**Preliminary Drainage Report
Meadow Lake Industrial Phase 1
El Paso County, Colorado**

April 2024

PCD File No. SP236

**MEADOW LAKE INDUSTRIAL PHASE 1**  
**MEADOWLAKE DEVELOPMENTS, LLC**  
 EL PASO COUNTY, CO

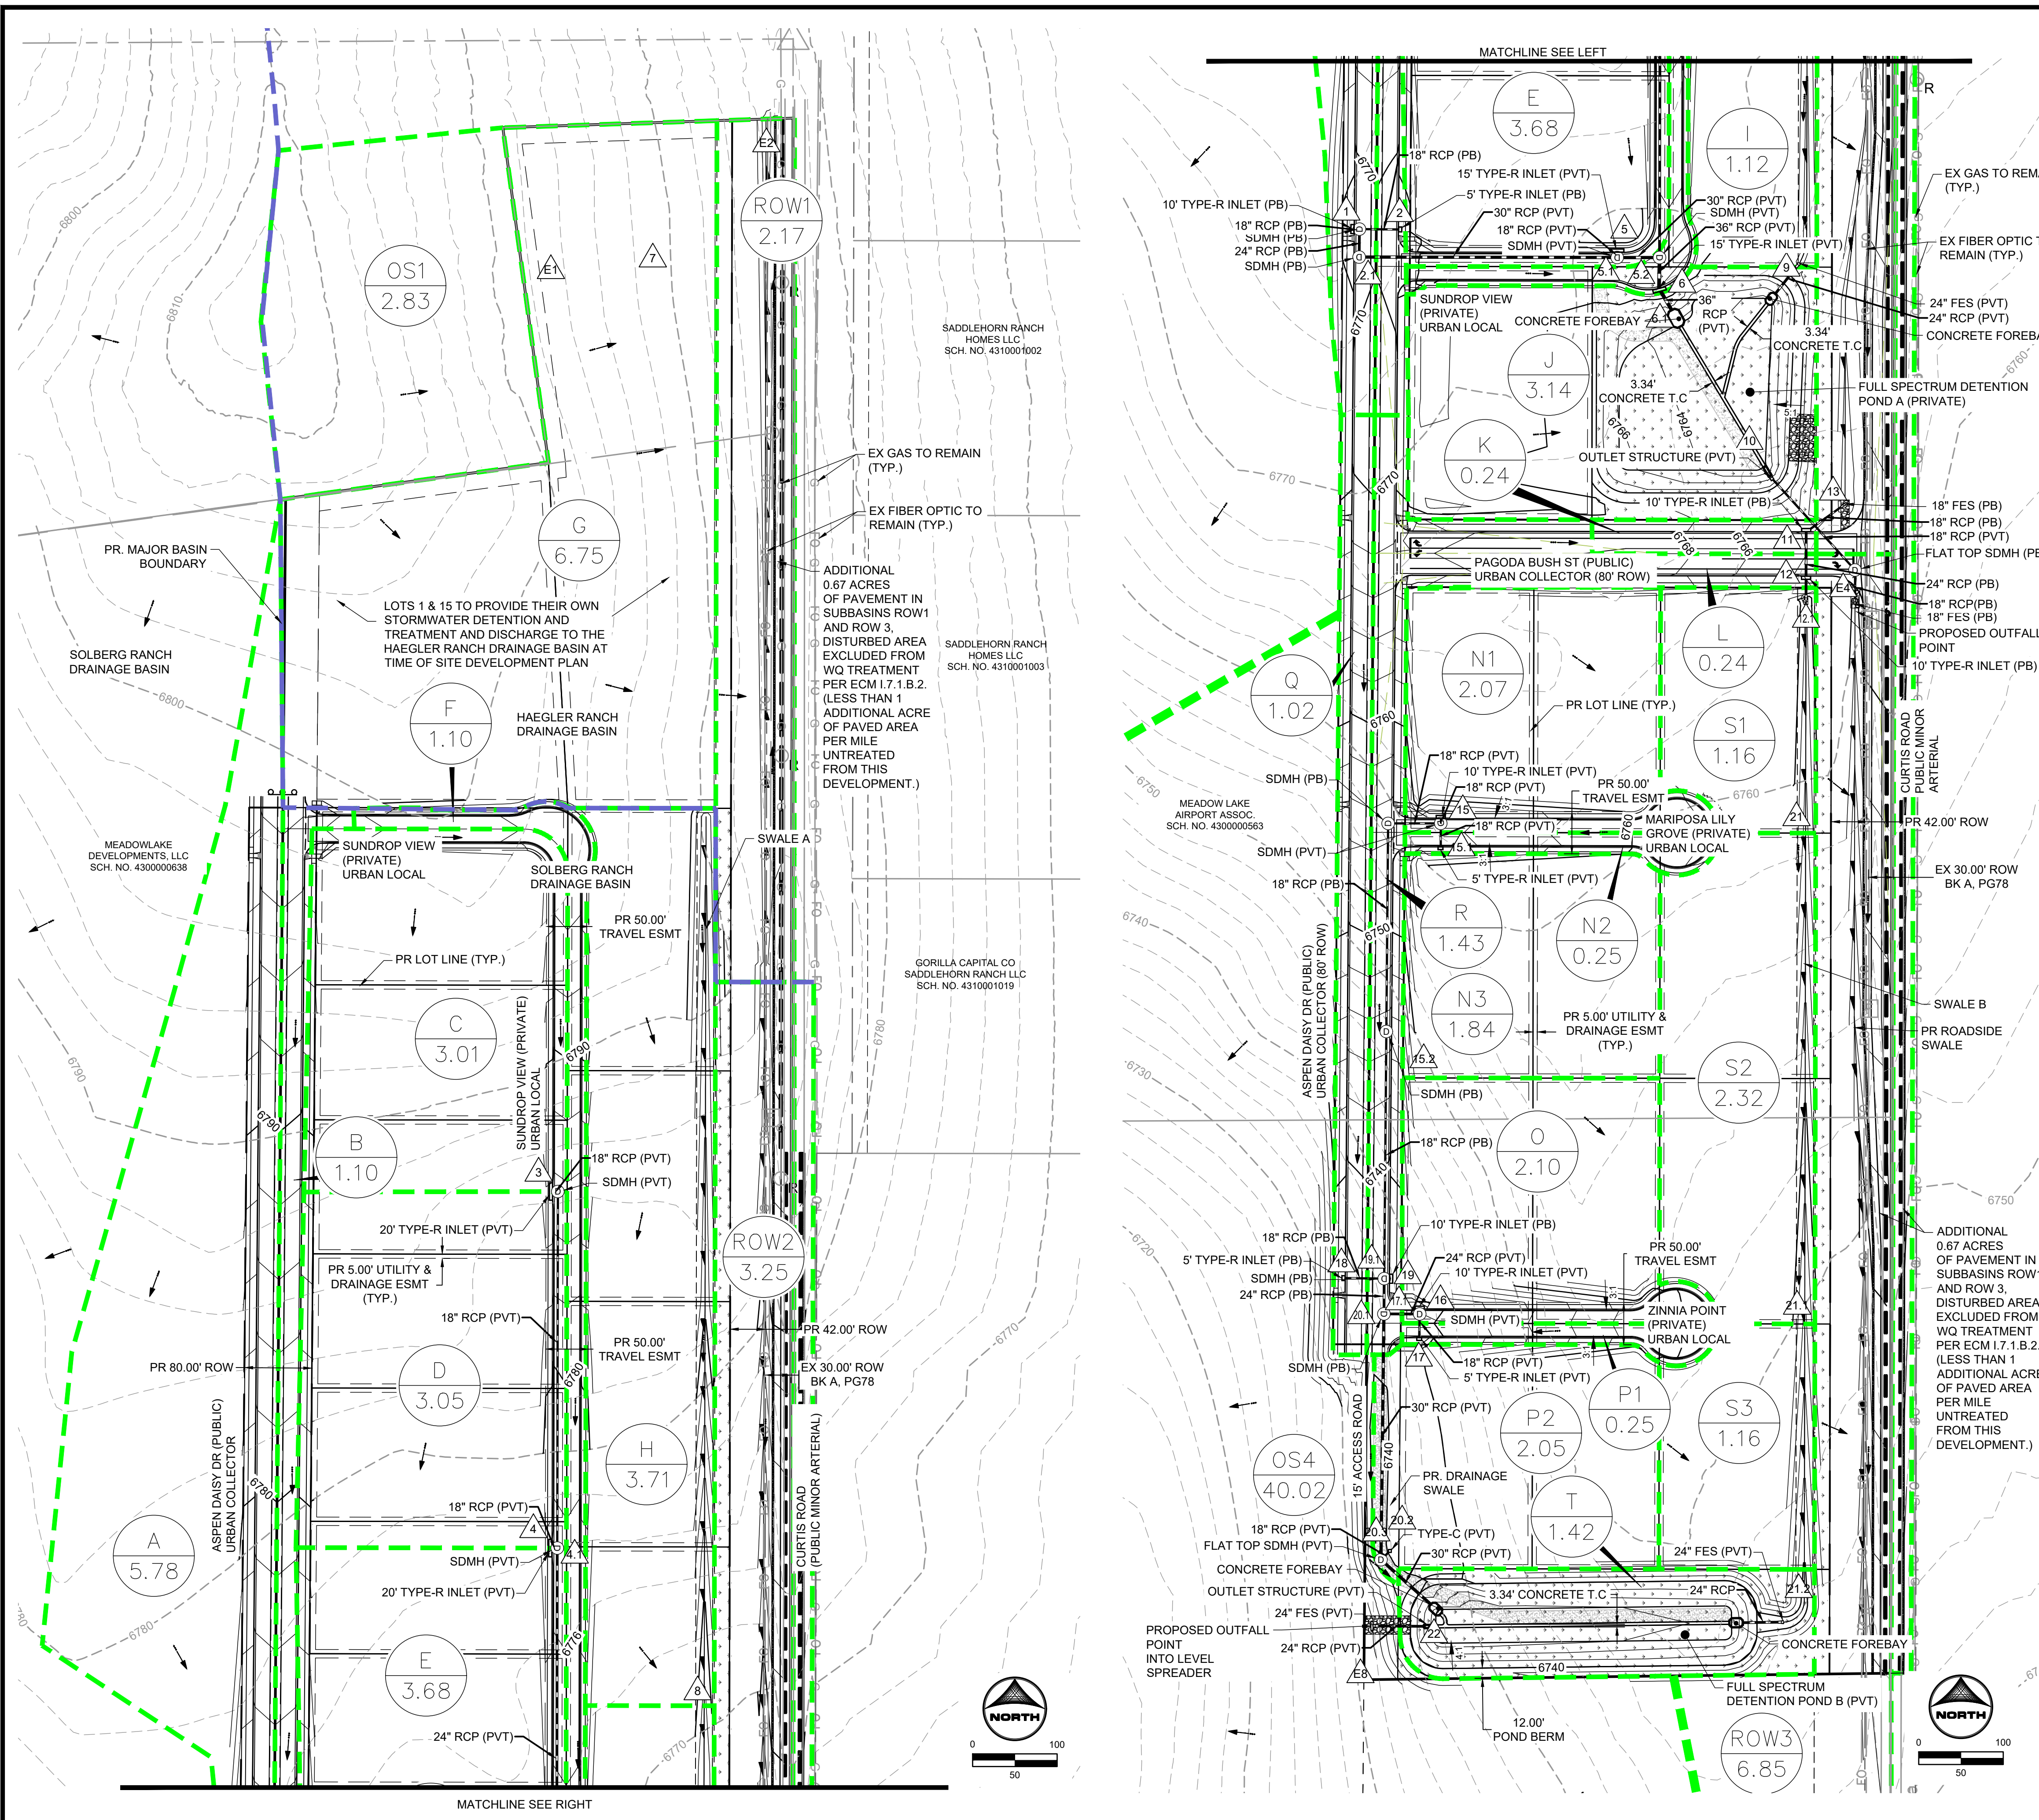
please clarify where flows from DP 7 are conveyed to. Is it conveyed to DP9?

Please clarify as there appears to be a storm pipe that collects flow from swale and then conveyed to the pond in the drainage plan.

Basin N should be broken up into multiple basins as a portion of the basin flows to DP15, another flows to swale B, and another to basin R.

Please account for the Curtis road improvements (widening and turn lane) required by this development. Coordinate with the traffic engineer. Be sure to address increase in flows/detention and water quality for these improvements

Added clarification to all basins.

Added clarification.

Basin N has been split up.

Accounted for and added description.
